An
Bord
Pleanála

Inspector's Report

ABP-312875-22 & ABP-312877-22

Development	N63 Liss to Abbey Realignment Scheme
Location	Culliagh South, Culliagh North, Liss, Chapelfield, Abbey, Clashard, Moyne and Newtown, Co. Galway.
Applicant(s)	Galway County Council
Type of Application	Approval under section 51(2) of the Roads Act 1993 (as amended), and associated CPO
Submissions on Road Project	<ol style="list-style-type: none">1. Transport Infrastructure Ireland (TII)2. Department of Housing, Local Government and Heritage3. Lucy Woods
Submissions on CPO	<ol style="list-style-type: none">1. Lucy Woods2. Padraic Conneely
Date of Oral Hearing	24 th November 2022

Project Title		N63 LISS TO ABBEY REALIGNMENT SCHEME			
Drawing Title		PROPOSED SITE COMPOUNDS LOCATION PLAN			
Project	Originator	Phase	Series	Type	Dept. Number
N63	ACM	PH03	0200	DR	HW - 0200
Drawing Number		Scale: 1:5000 @A1 / 1:10000 @A3		Date: 21.12.2021	Job No: 60597858 Rev: P02

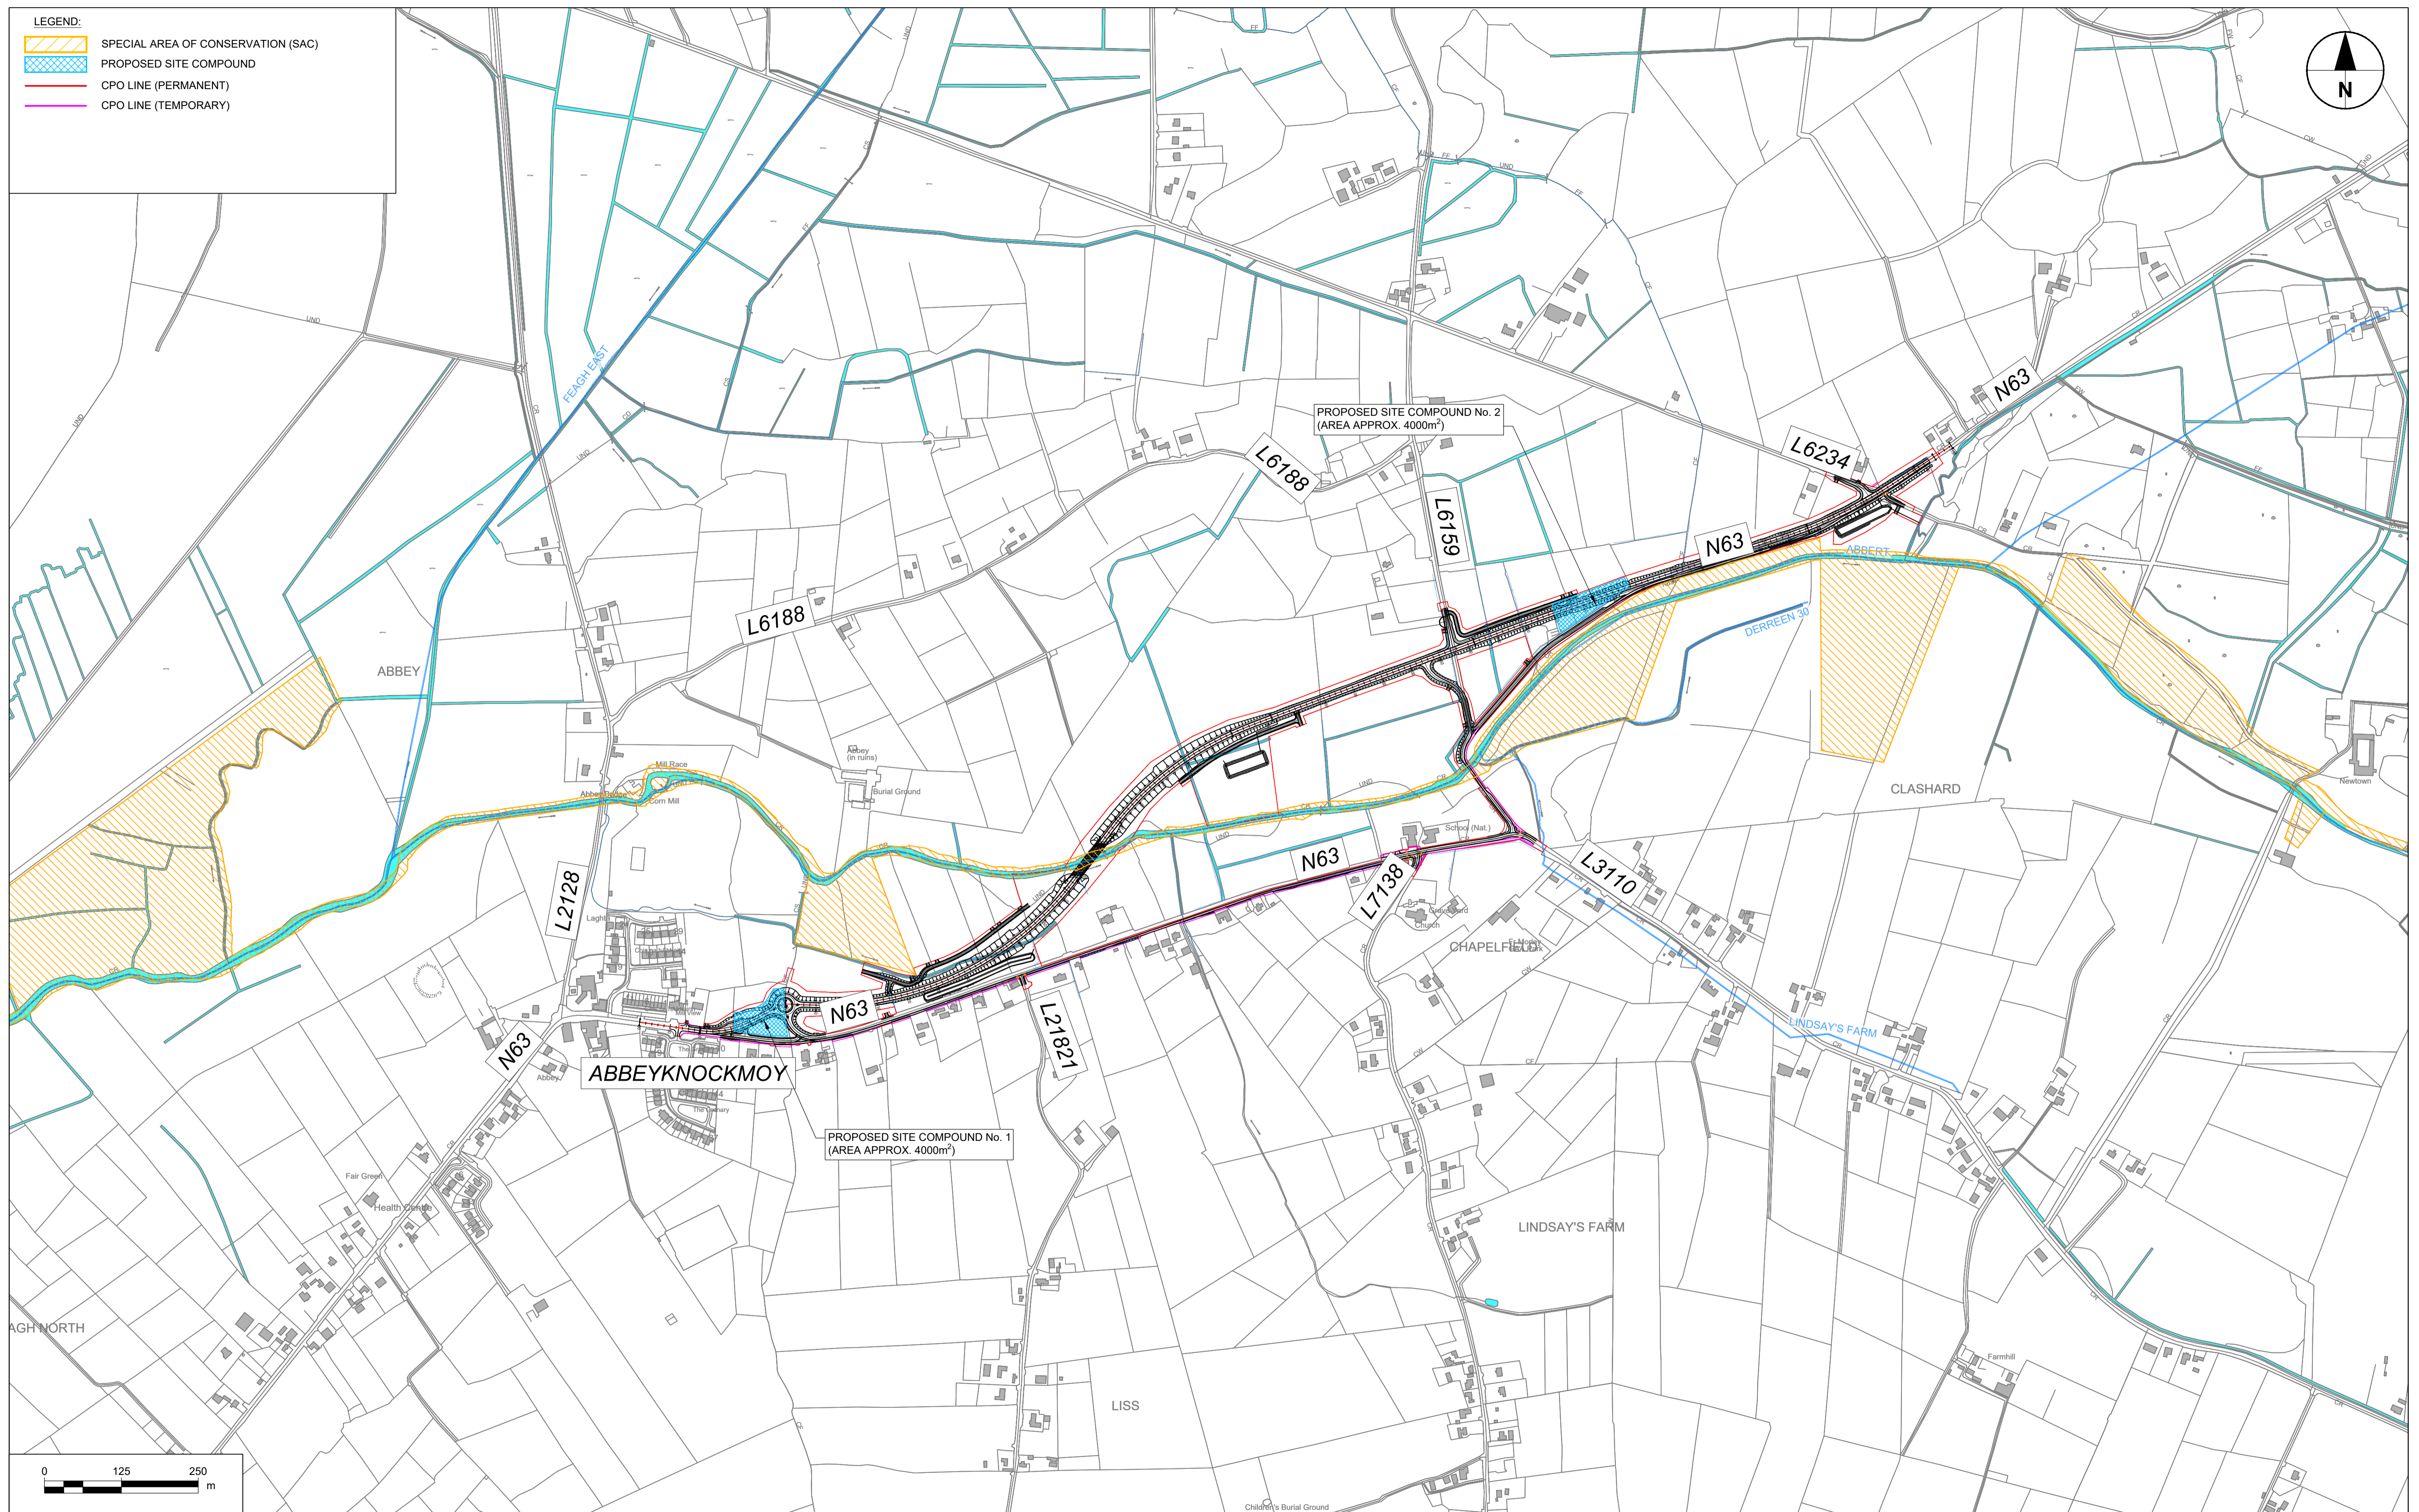
- 6.1.8. There are concerns regarding the location of site compound no. 2 within 13 metres of the SAC boundary. It is an area of wet grassland with water filled ditches. It is near the petrifying spring and there may also be other petrifying spring habitat. The Board should be satisfied that mitigation measures are adequate to accommodate this compound having regard to the SAC.
